**From:** [Linda Scalzo](#)  
**To:** [Deb Estrada](#)  
**Subject:** Purposed East Seattle Development  
**Date:** Wednesday, January 24, 2024 10:40:58 AM  
**Attachments:** [EAST SEATTLE updated concerns 2024.docx](#)

## EAST SEATTLE / BOYS & GIRLS CLUB PROPERTY

Builders asking for 14 houses on 2.88 acres

8/30/23
 JOB NUMBER:
13-118
 SHEET NAME:
SP-01
 SHT **3** OF **10**

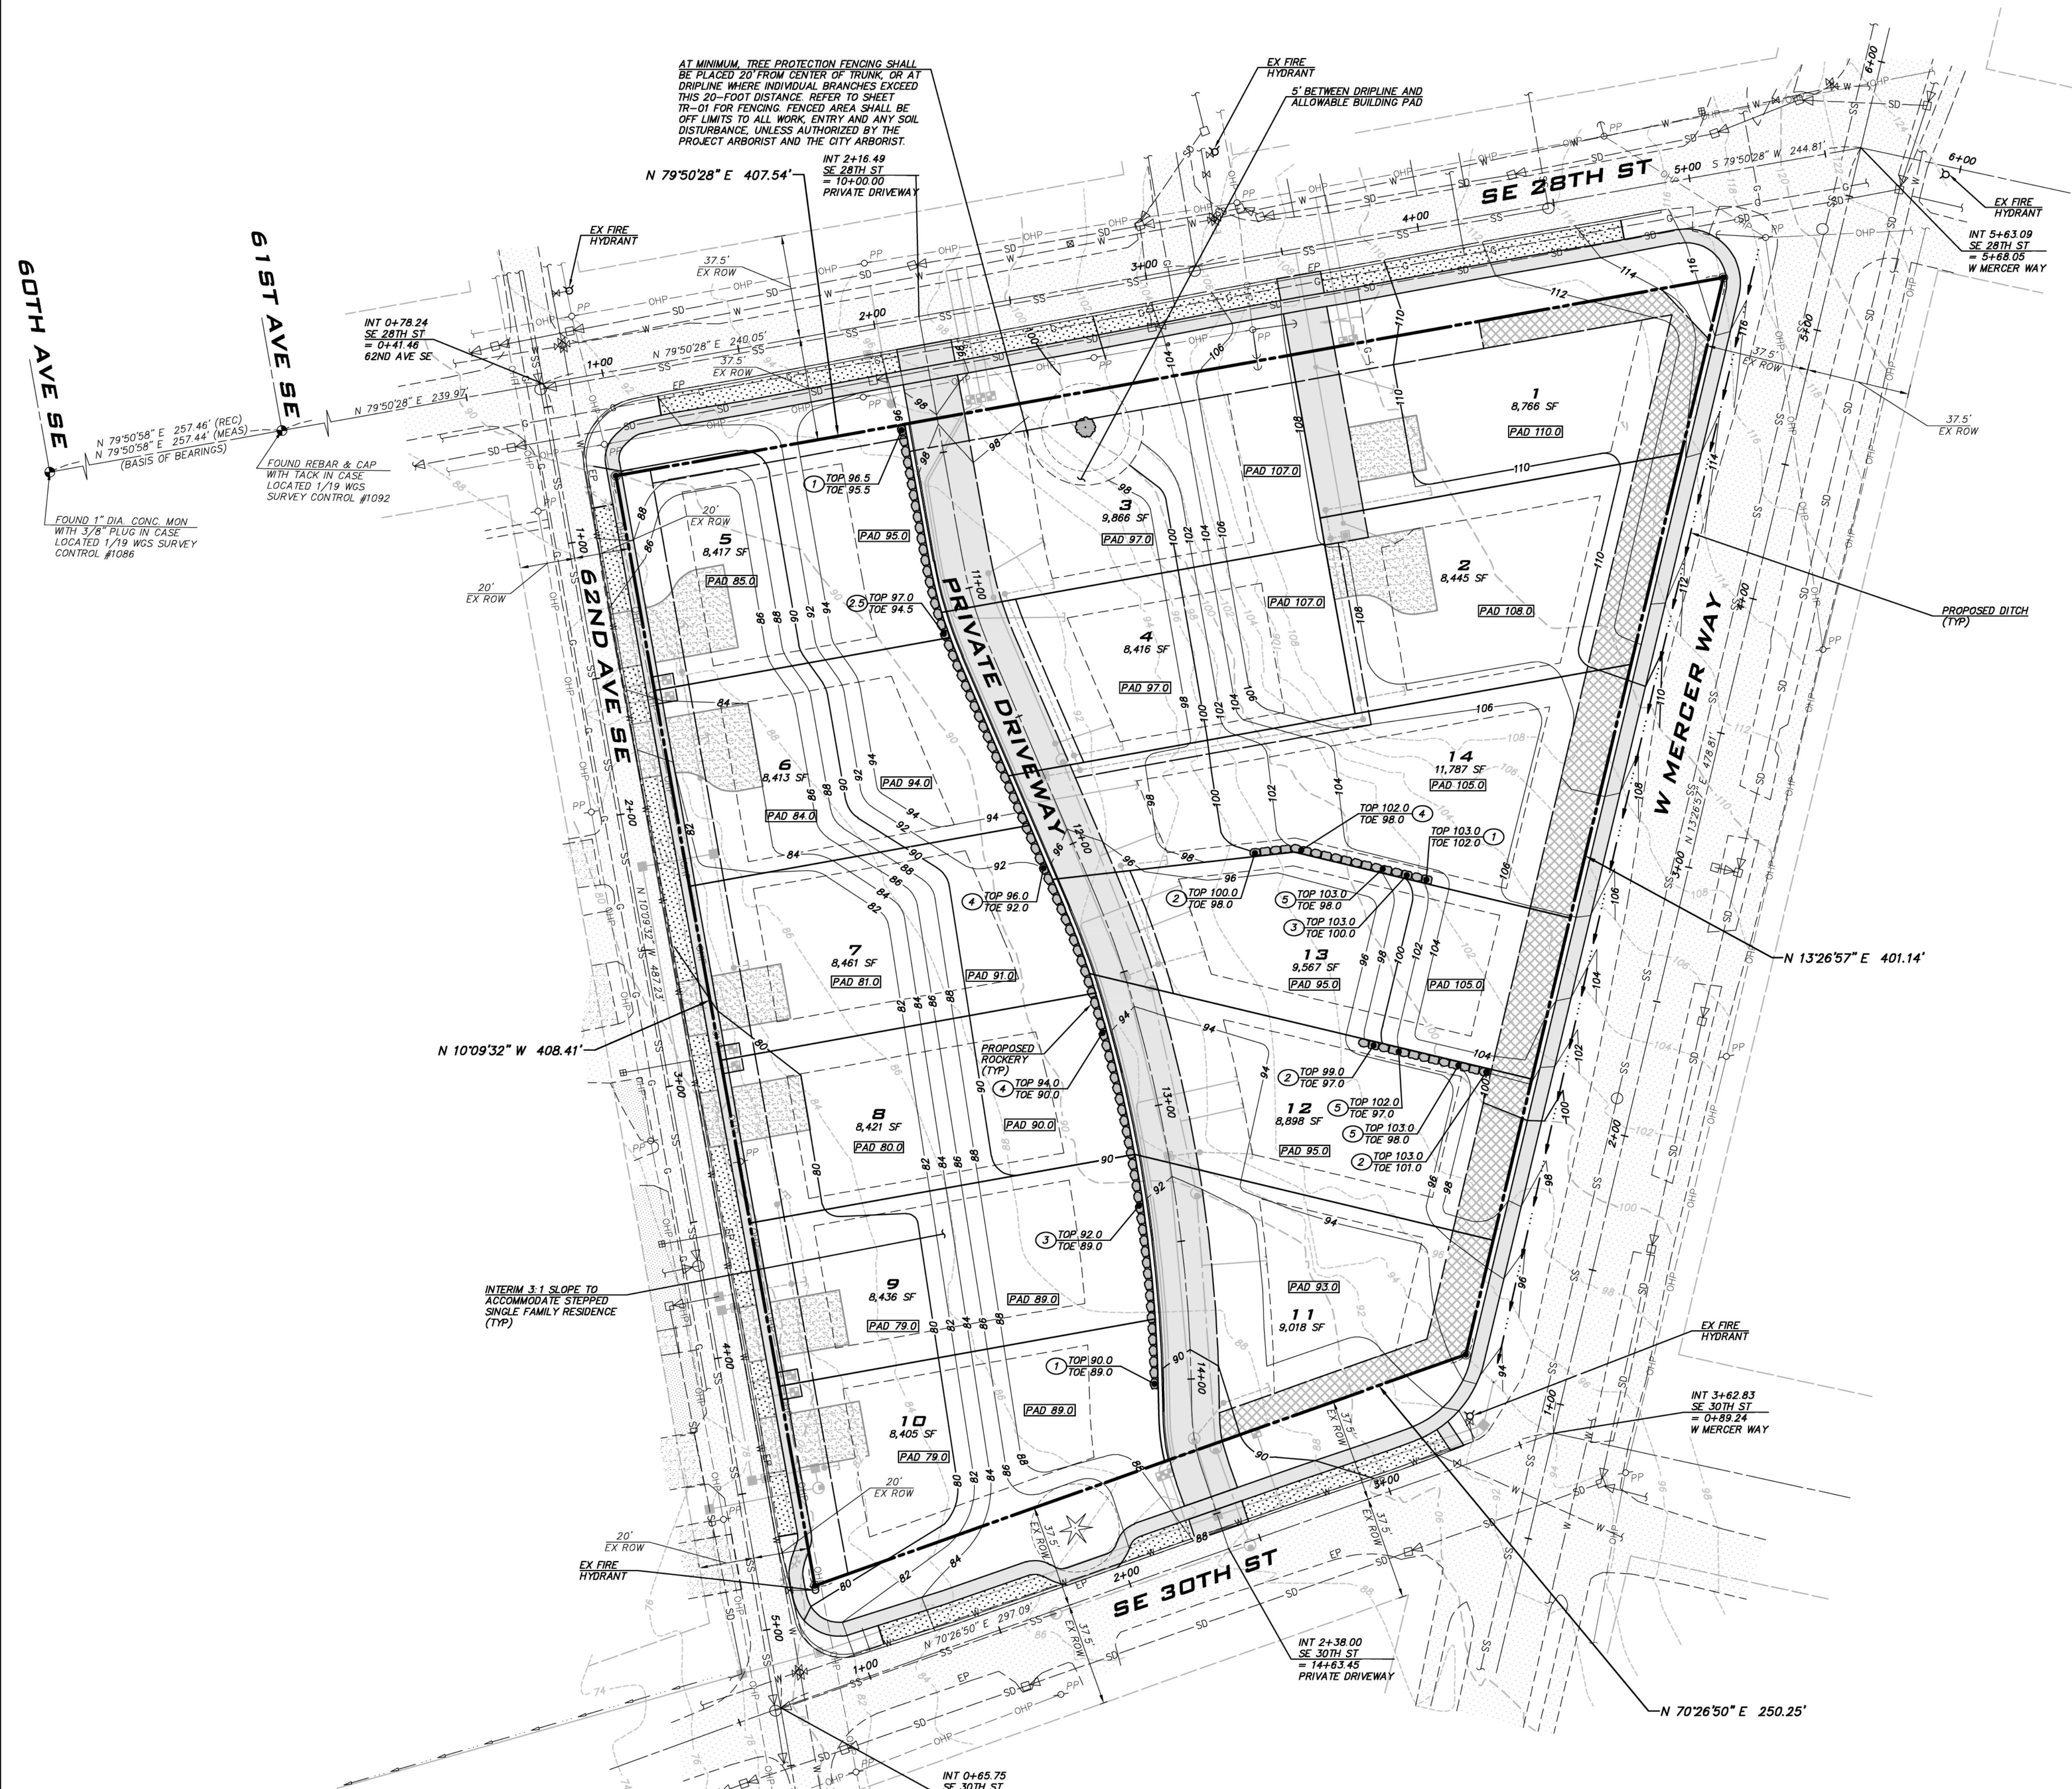
- Reduce number of houses to help address concerns
- Are there Sidewalks in the development and along West Mercer Way - For the safety of pedestrians, the developer should be required to install a paved walkway all around this new development.

- Is the Builders still asking for 52% impervious services; Is the maximum usually 40%
- Where is the dedicated public open space.
- Traffic and pedestrian safety concern. All access to houses and garages should be from within the development and not from 62<sup>nd</sup> Ave SE.

- Not enough designated Parking – do all houses have a minimum of 2 car garages? Where do visitors and service people to all the homes park? Homeowners' extra cars?

- There should be a uniform fence along W Mercer and 62<sup>nd</sup>. No one wants to look into people's back yards. Most of the proposed trees along W Mercer are deciduous and don't form a hedge like border. Curious about the choice of 4 Weeping Nootka False Cypress along W. Mercer. They don't seem to fit with the look of the other trees.

PRELIMINARY GRADING PLAN
2825 W MERCER WAY
PRELIMINARY PLAN
 PARCEL #2174502425
 CITY OF MERCER ISLAND WASHINGTON

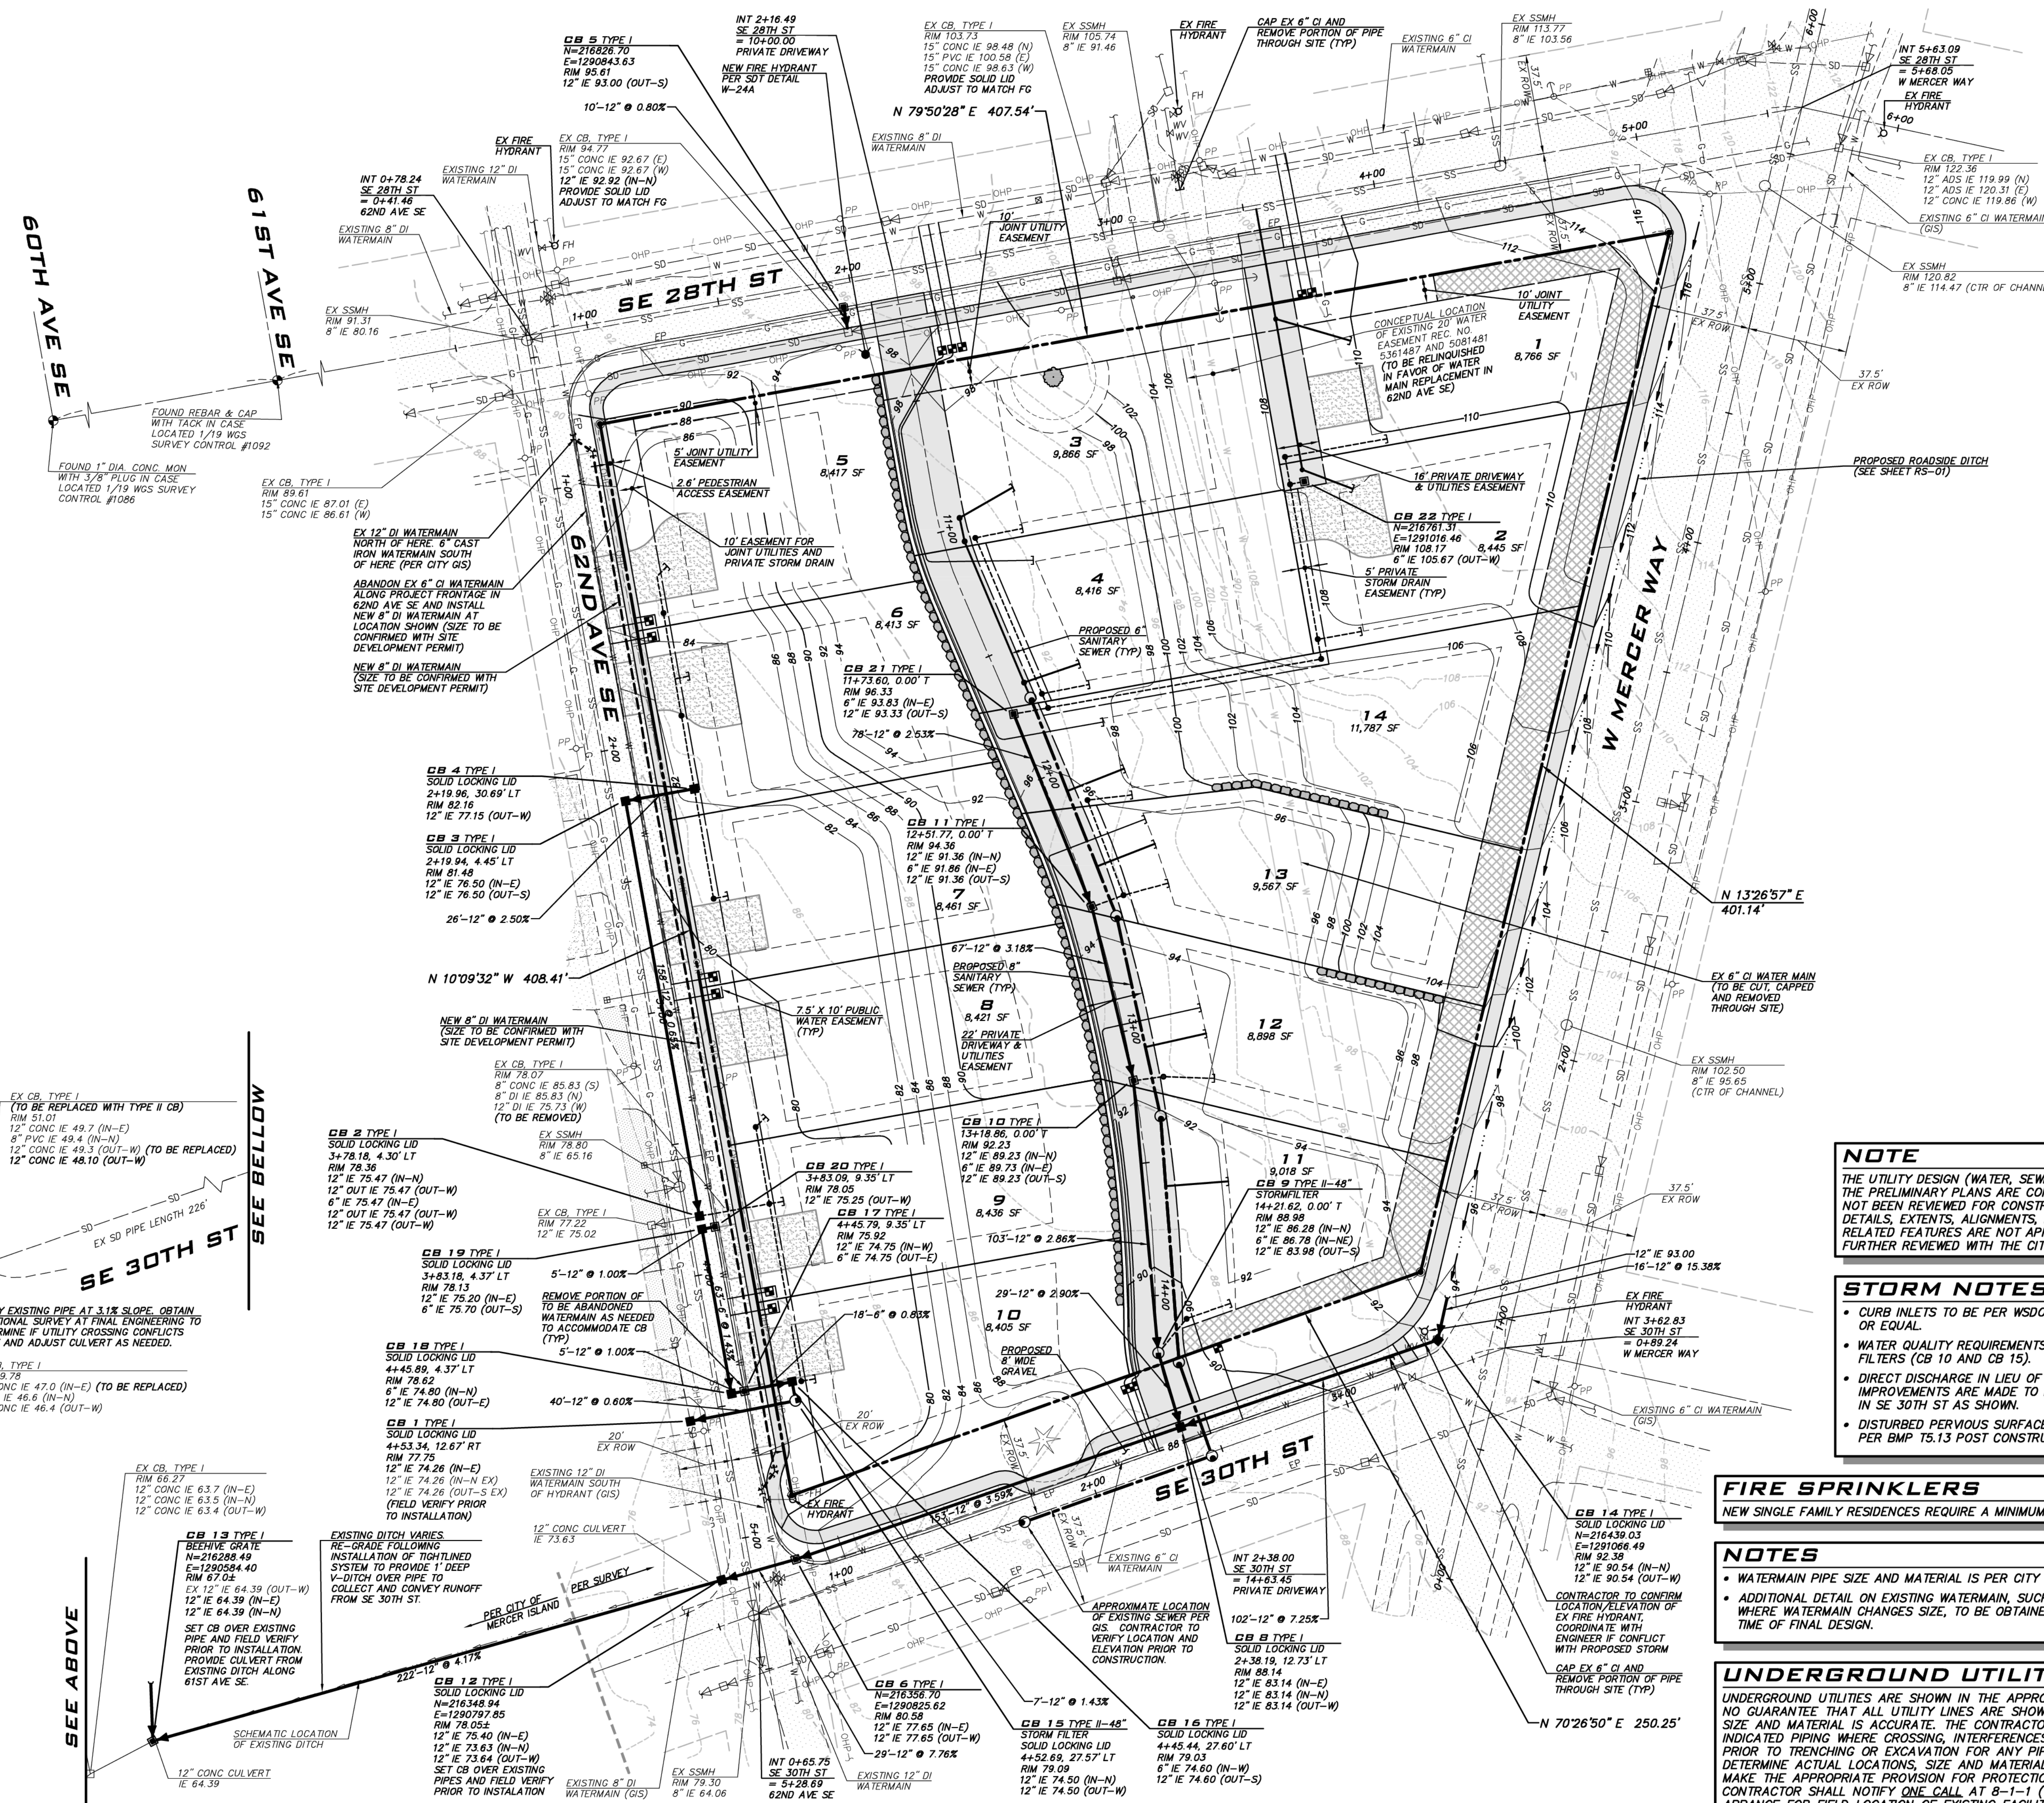
- No variance should be granted above the 30' max height on homes, including FP, railings, or other structures. I don't know if there is any way to monitor drastic changes being made to the elevation of the property. For example, the house to our east was able to bring fill dirt in to raise the new house and yard so now their back yard dirt directly east of the shared fence is about 5' higher than our side. I am concerned about drainage problems in an area that already gets a lot of run off from the hill.
